J.S. THOMPSON
ENGINEERING, INC

December 19, 2024

The "Avery" plan, truss layouts and drawings provided by Comtech were reviewed for 2885 Lemuel Black Road in Bunnlevel, North Carolina to address the differences between the sealed plan and roof truss layouts as noted by the inspector.

ATTIC FLOOR
FRAMING PLAN

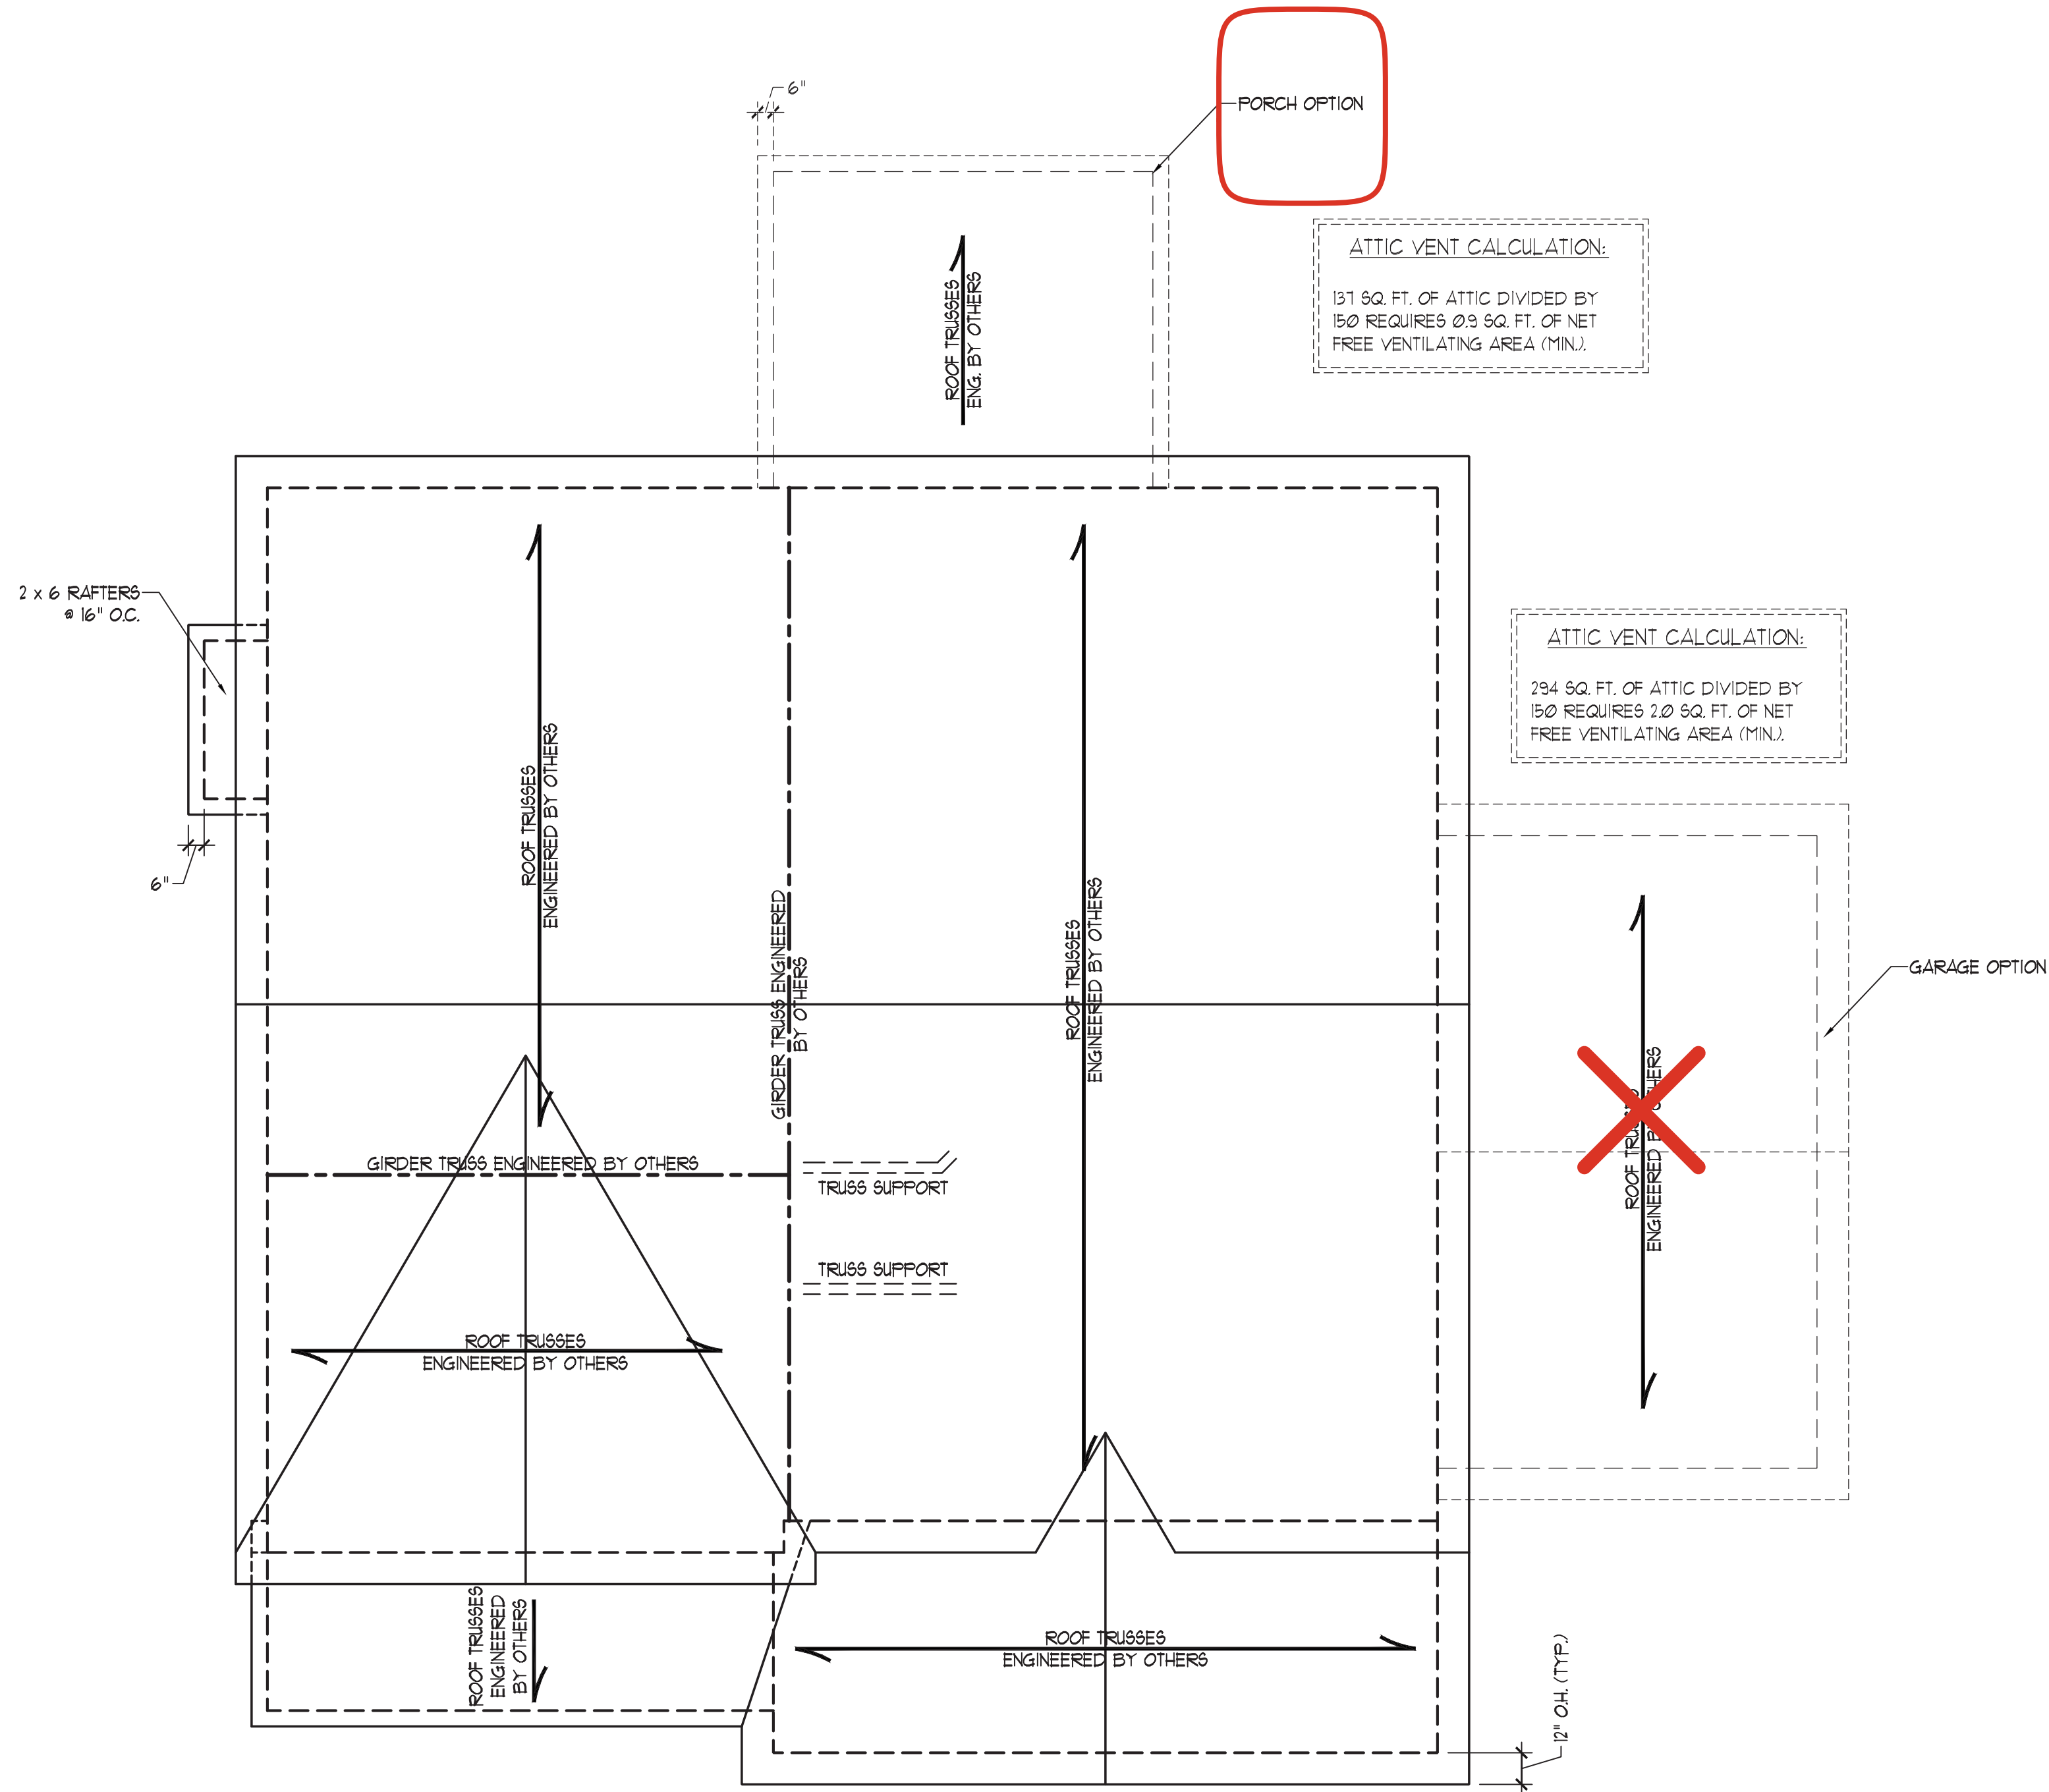
The roof layout was modified to remove the truss bearing walls on either side of the second floor hallway and to remove the front to back girder truss in order for trusses to bear on the bedroom #4 wall. An LVL was added above the hallway to support the girder truss above the stairs. Analysis revealed the following:

- 1) The front to back girder truss is not required. The (2) 1 3/4" x 9 1/4" LVL above the hallway is sufficient to support the applied loads from the girder truss above the stairs. Install (3) 2 x 4 at each end of the LVL and block solid to the foundation.
- 2) A minimum (2) 2 x 6 header with (1) jack and (1) king stud is required at the new load bearing laundry closet wall. Block the point loads solid to the foundation
- 3) There will be no offset load or point loads to support within the joists above the garage.
